Our Ref: DA S29/3/97-MOD-1

**Eastern Creek Karts (DA S29/3/97)
Section 4.55(2) Modification for Earthworks and Drainage (MOD 1)**

Attachment 1

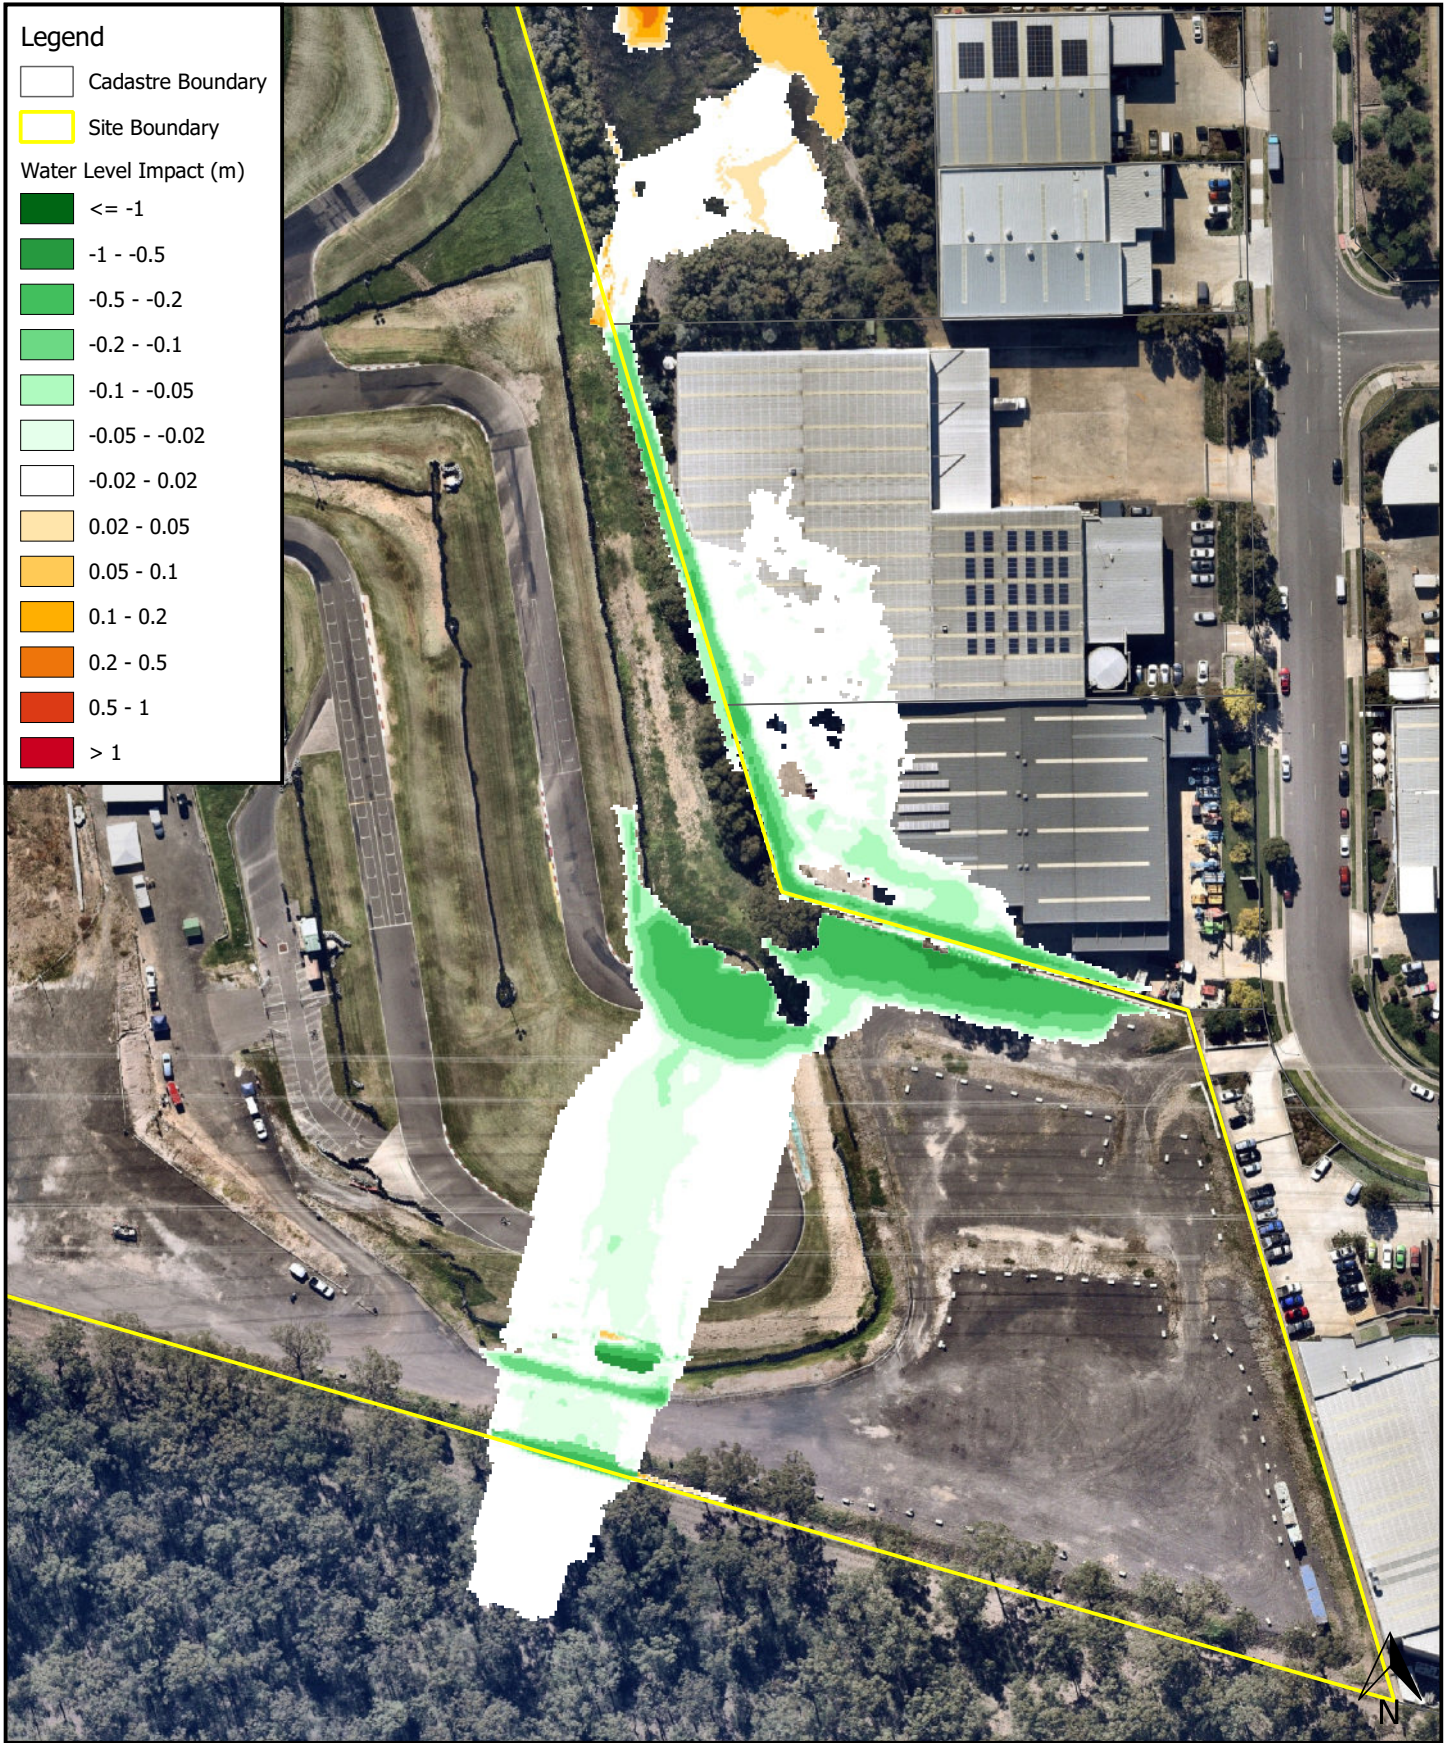
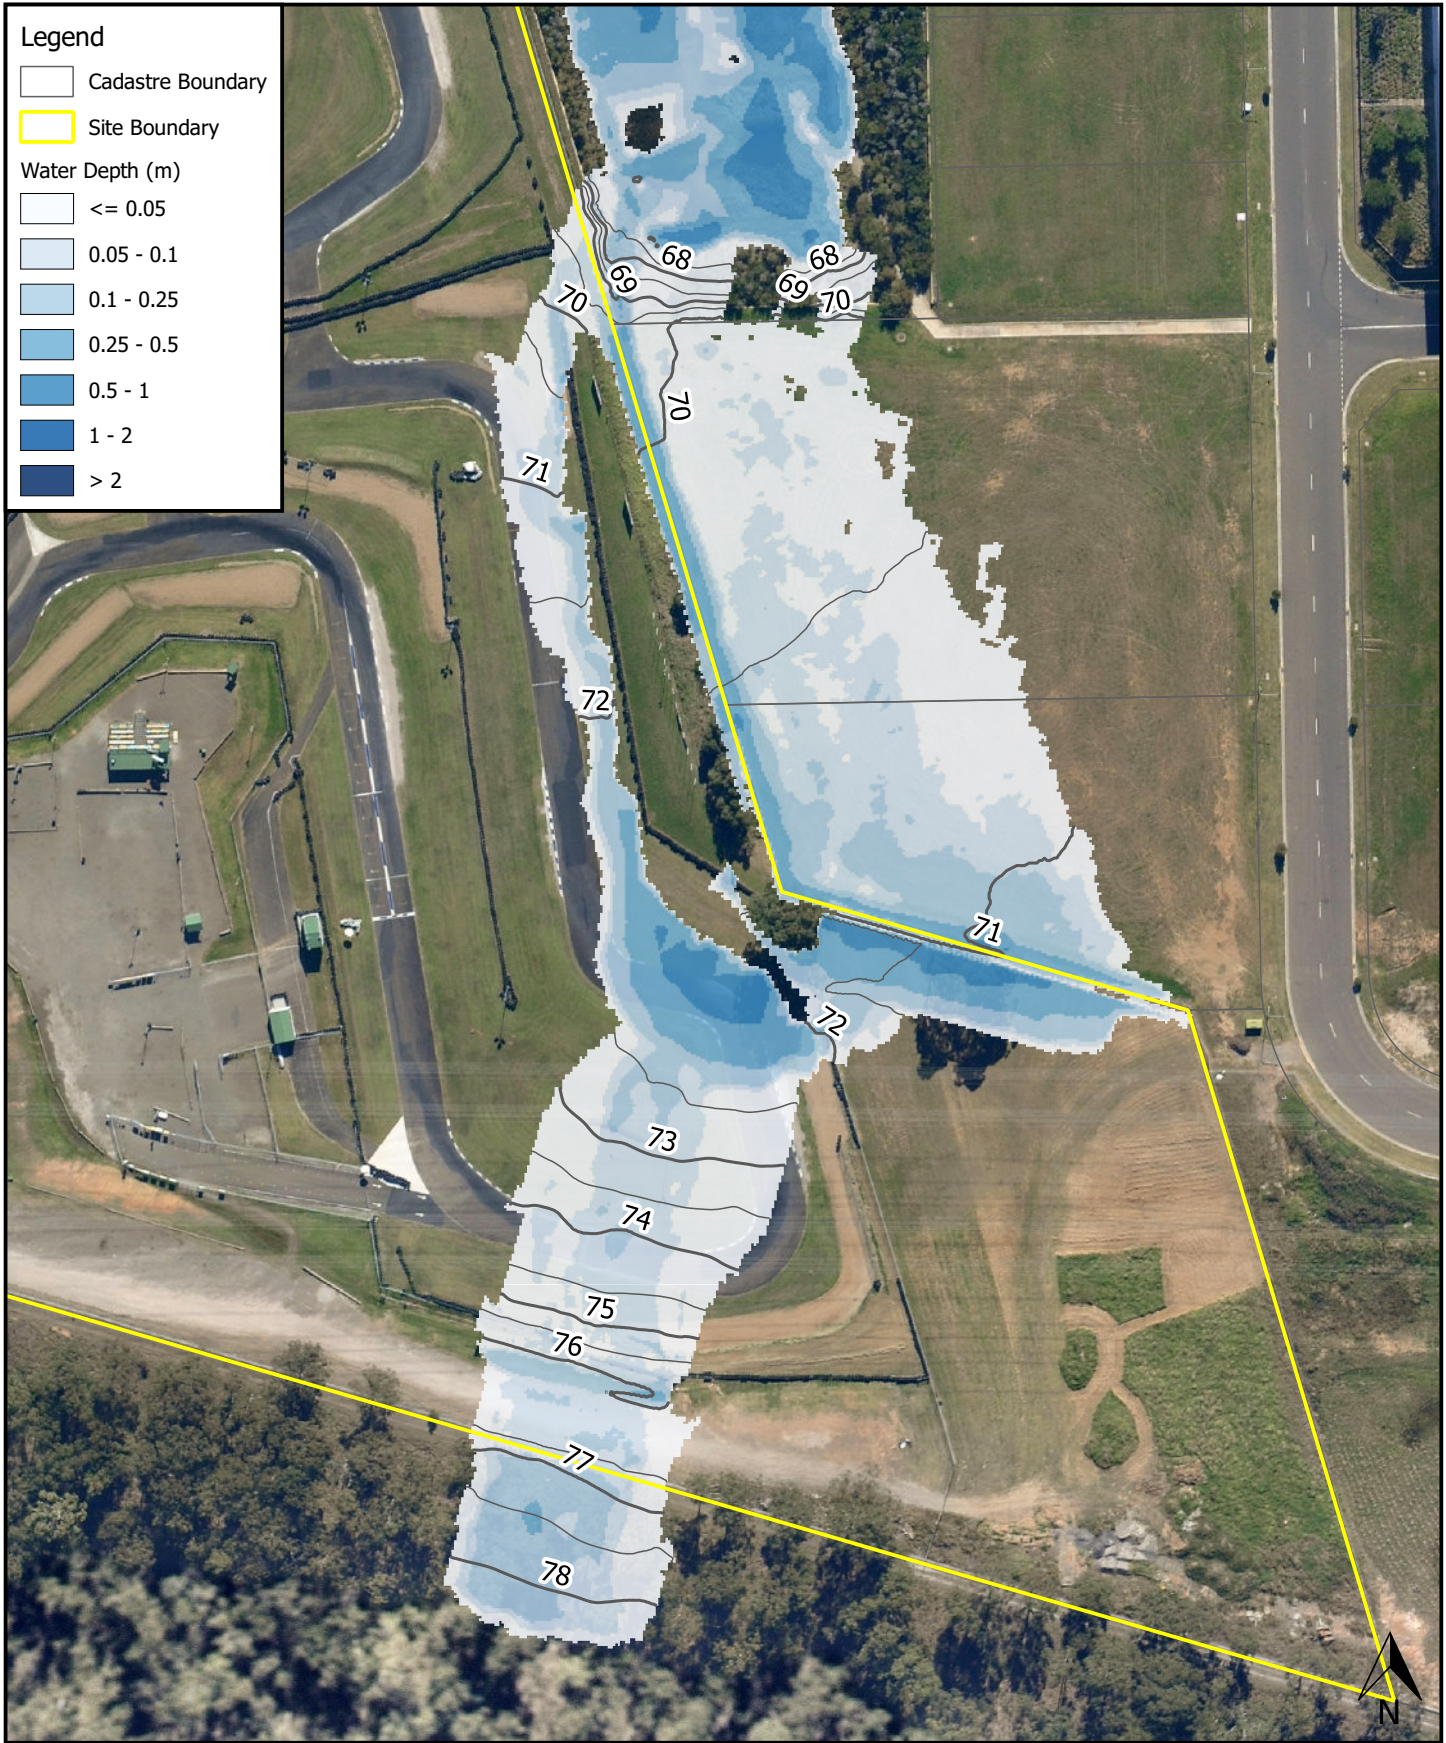
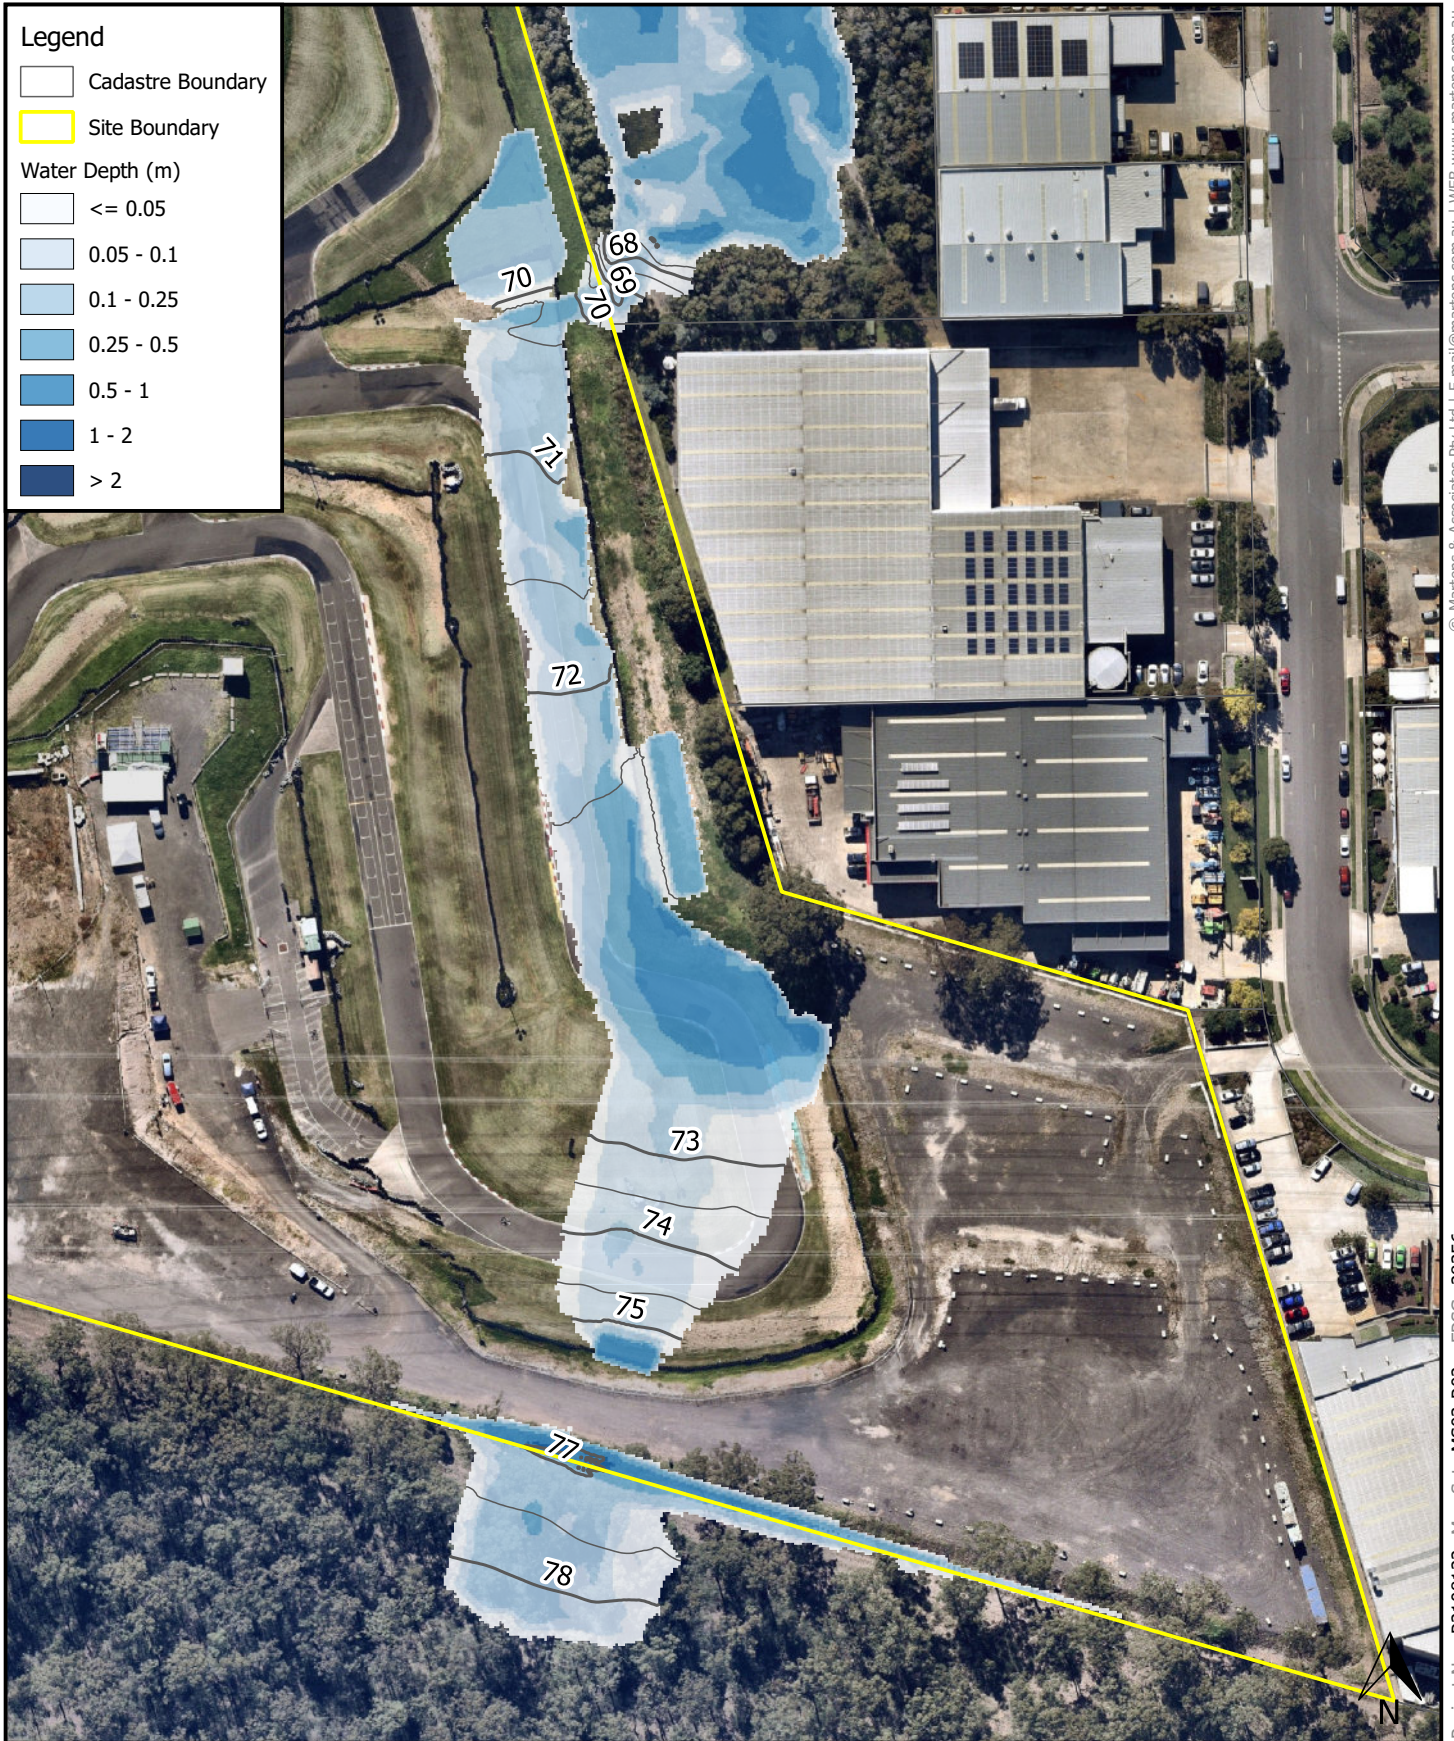
- 2.4 Clarify if the proposed finish level of the access ramp over culvert 1A102 is 0.67 m above the toe of the upstream batter and clarify if TUFLOW Plan FL04 dated 16 April 2021 still requires the PMF to flow over the top batter as shown. If this is the case, please clarify PMF design peak flood depth and velocity over the access ramp.
